## Inspector's Report ABP-315438-22

Whether alteration to an existing access is development and whether it is exempted development.

5 New Road, The Demesne,  
Westport, Co. Mayo.

EXISTING SITE LAYOUT PLAN

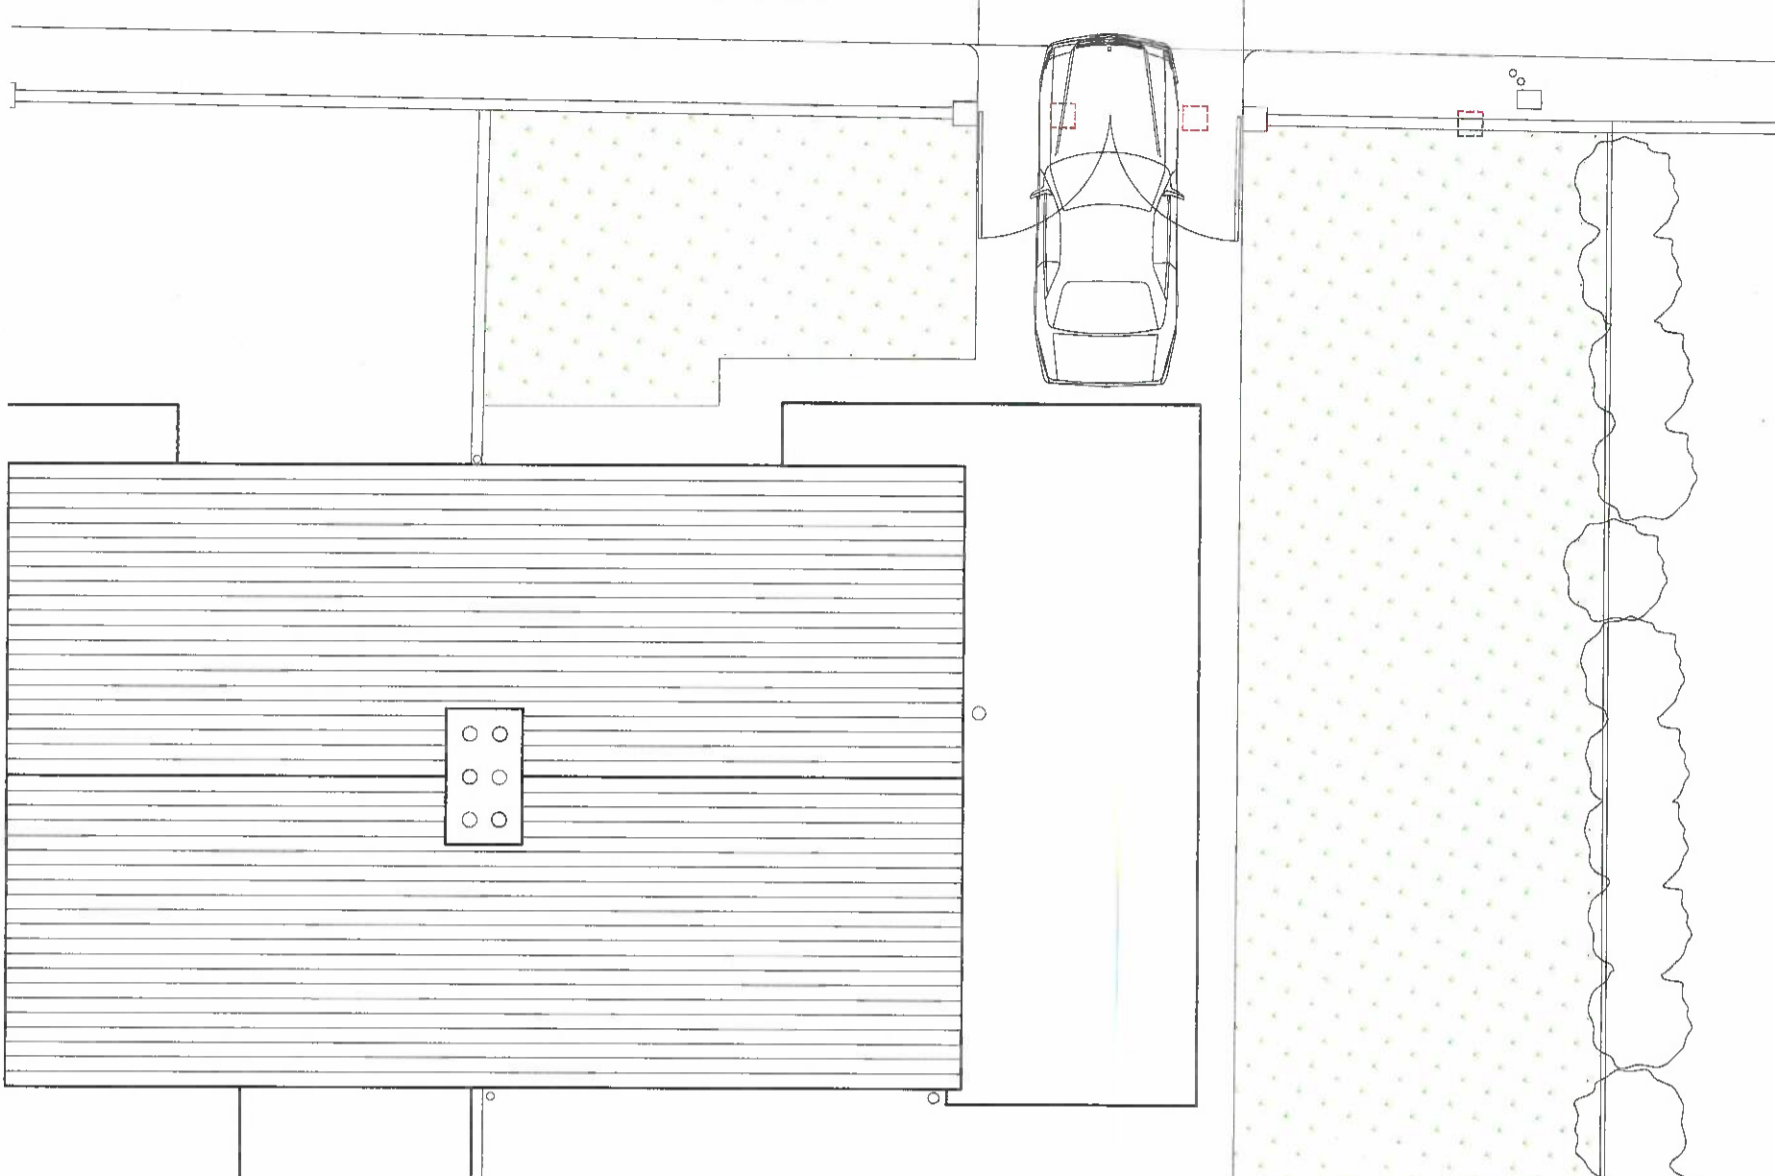
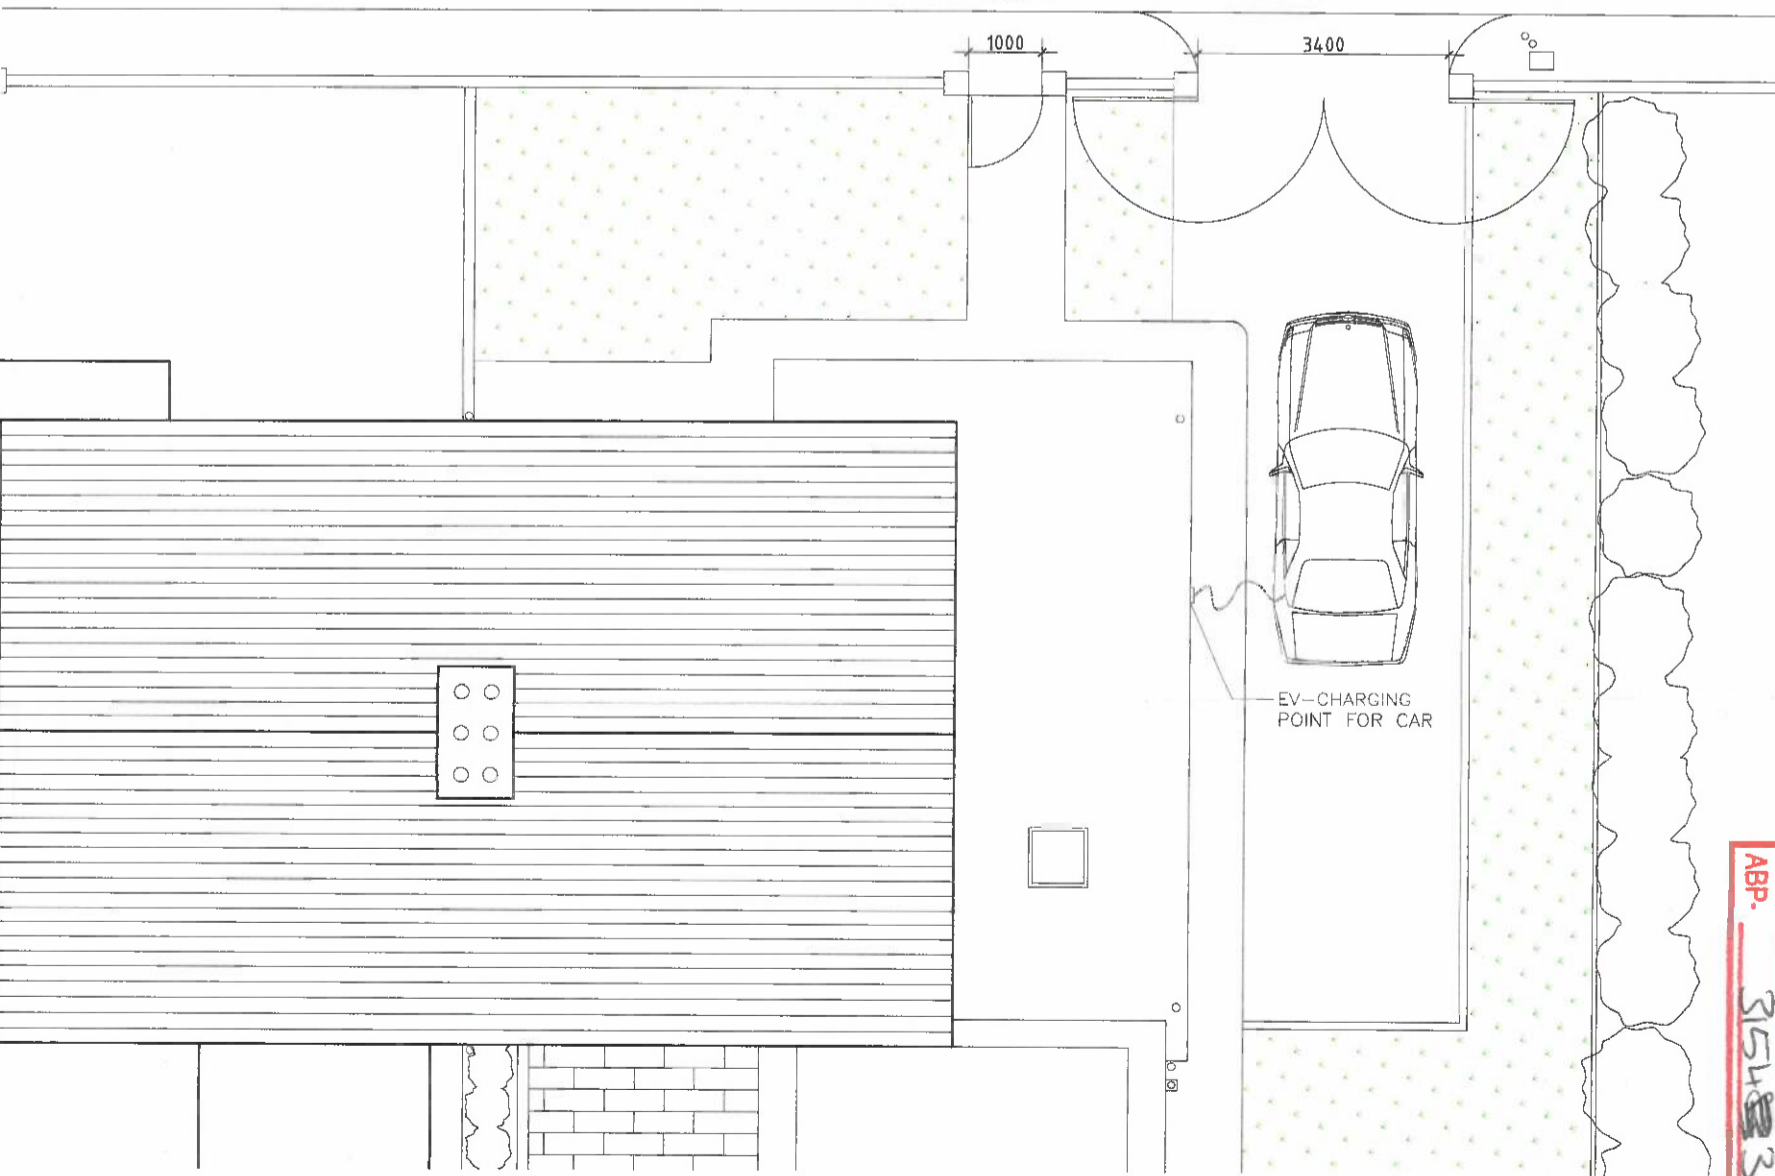
- 8.3.5. Returning to the question of whether the alteration is substantial or material, I note that the original vehicular access was 3.6m wide and that its replacement is 3.4m wide. The overlap in the footprints of these two accesses is minimal at 0.45m, and so the greater portion, i.e., 2.95m, of the replacement access comprises a new opening. Within the vacated space of the original opening, a new pedestrian access, 1m in width, has been formed. Accordingly, the development has resulted in the effective shunting of the original vehicular access eastwards and the formation of a new pedestrian access in its place. I consider that these revisions to the access arrangements to the site are material. In this respect, it is of relevance that, under ABP-304360-19, the Board decided that an increase in width of 0.6m in a domestic vehicular access was "material", albeit this increase involved the extension of an existing vehicular access from 3.6m to 4.2m in width.
